FATAL FLAWS SUMMARY - UNDELIVERABILITY

Objections submitted in response to East Pye Solar
PINS Reference: EN0110014

Land Parcel Sub-site 4A and Sub-Site 4B

Figure 11.4: Likely and Suitable Routes to the Scheme
Sites 4, 5, 7A-F
Revision A

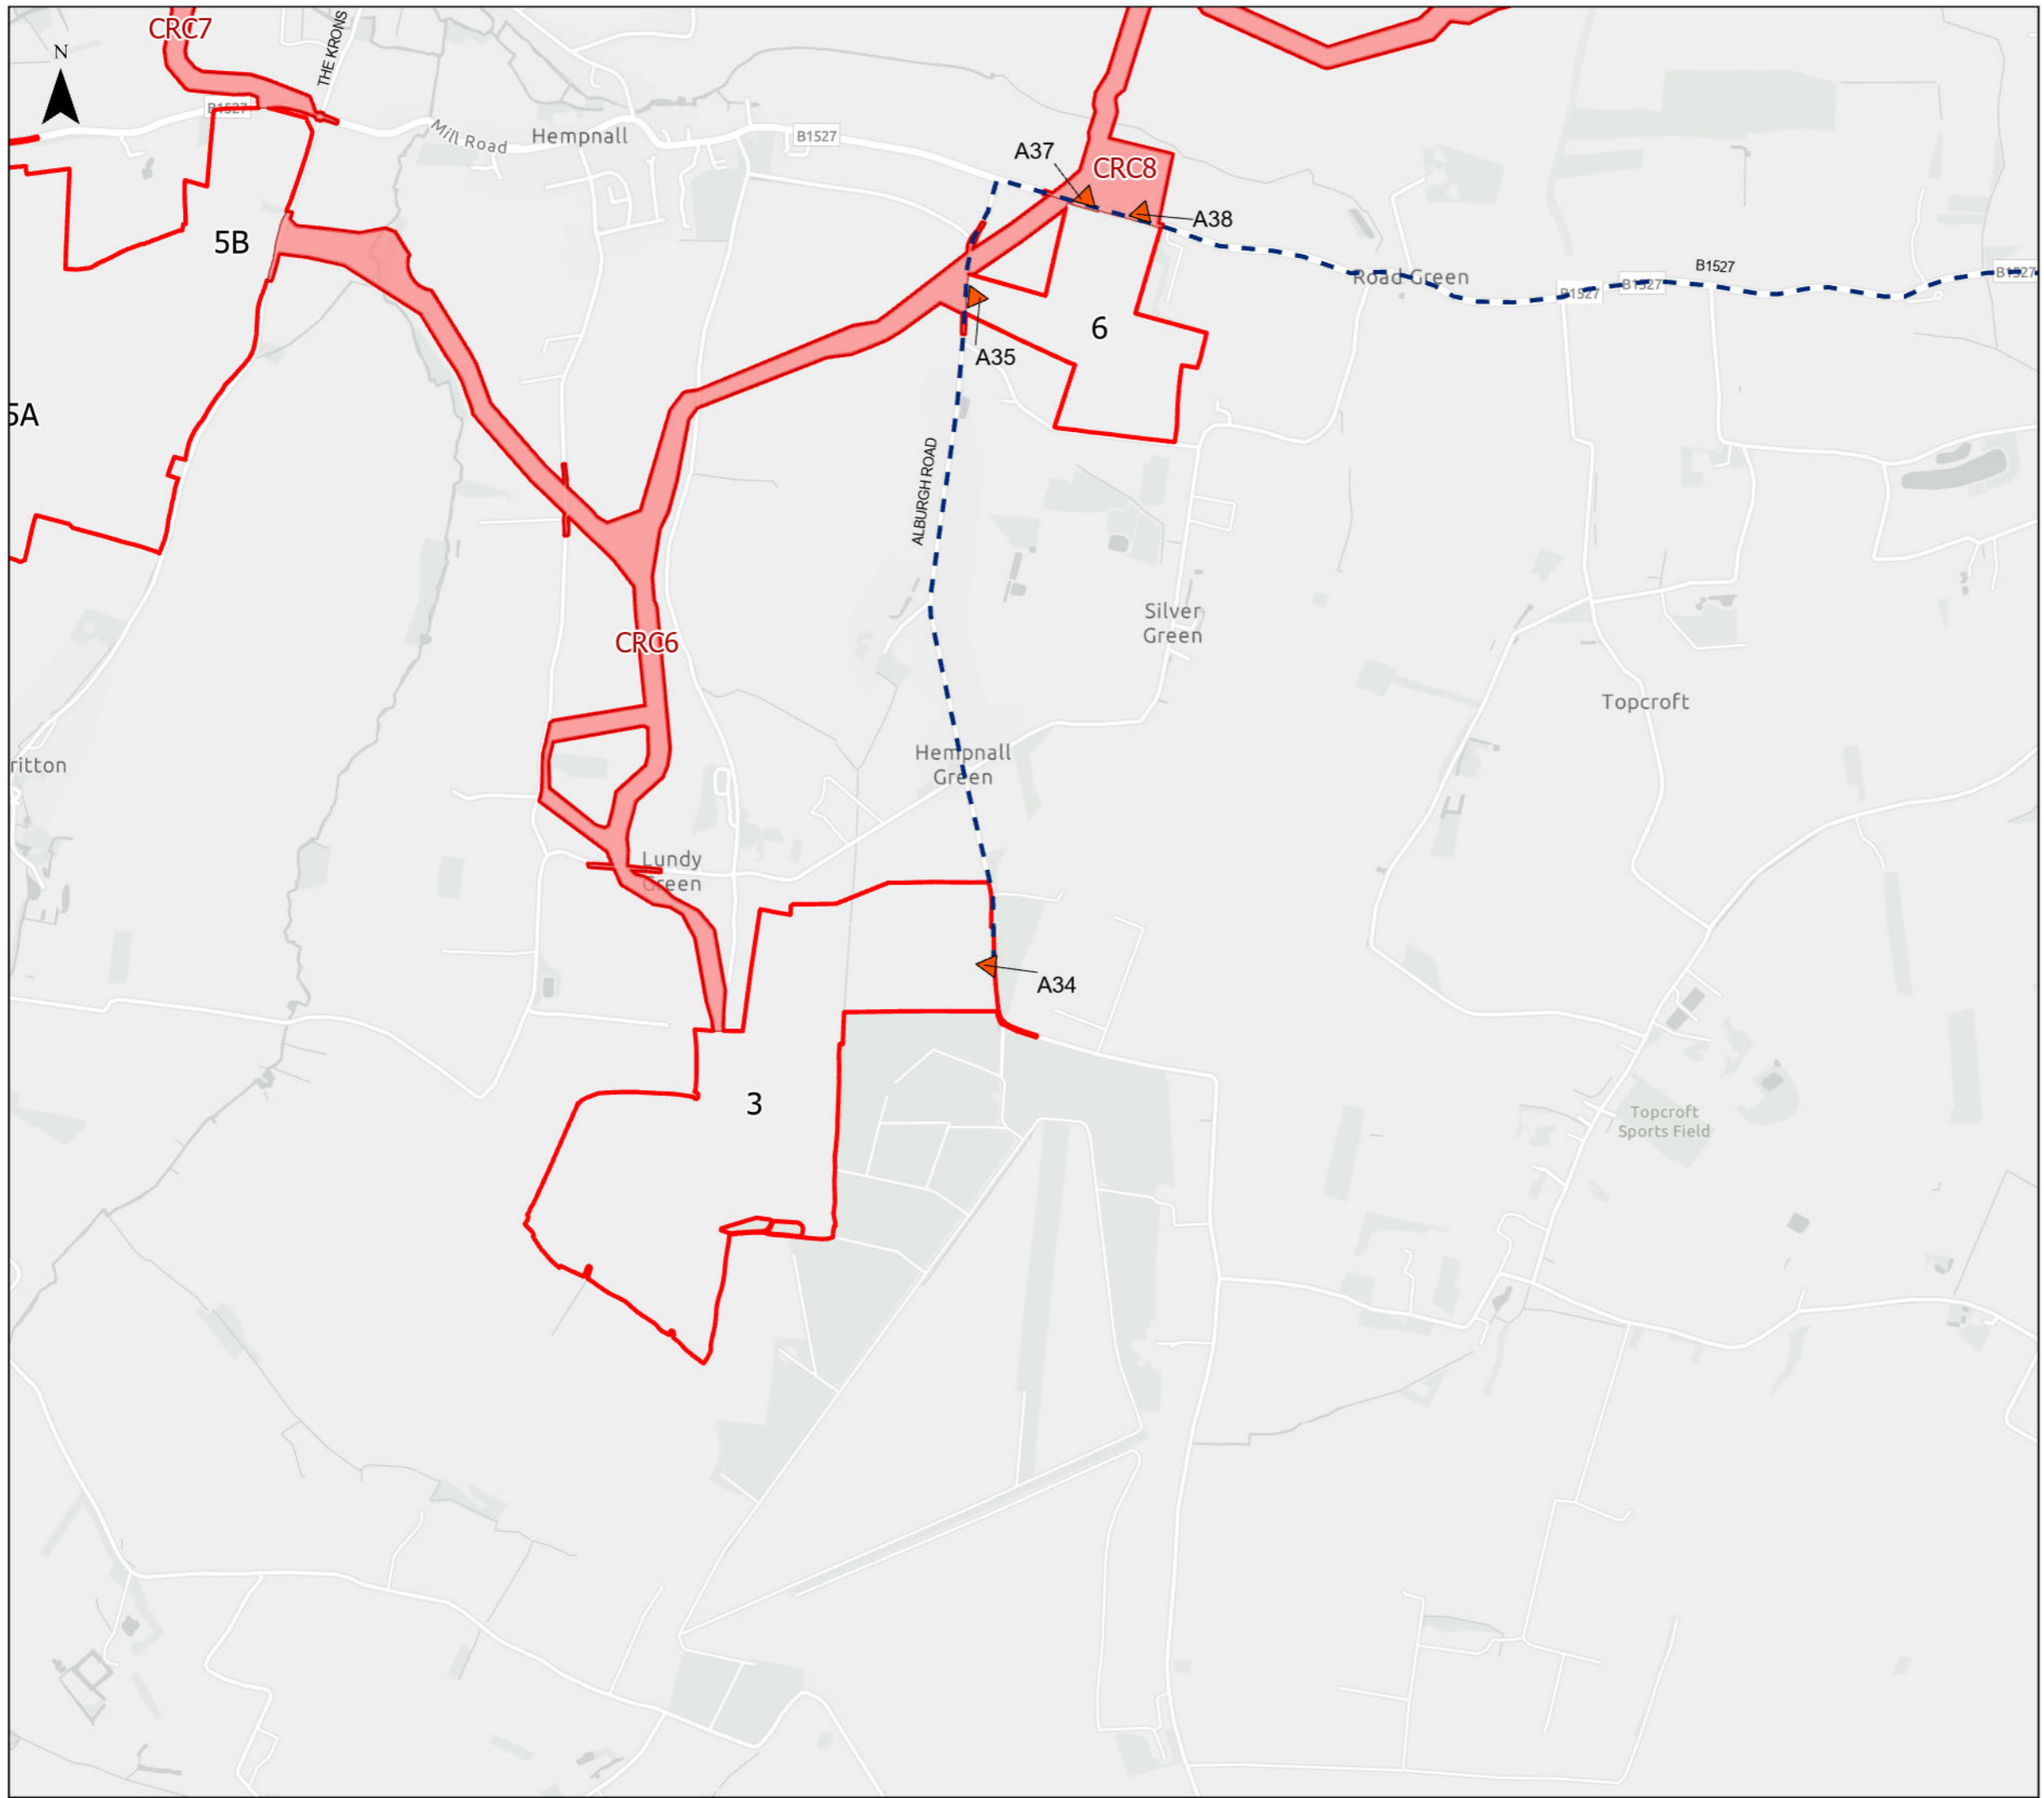
7. Highways safety, glint and glare, and access conflict (FATAL)

Land Parcel 4 straddles the A140, a major strategic route. The proposal introduces:

- severe glint and glare risk to road users;
- conflicts with existing congestion and planned highway changes;
- unsafe interactions with public footpaths and local access.
-

These impacts raise road safety concerns, not merely amenity issues, and cannot be reliably mitigated over the lifetime of the development.
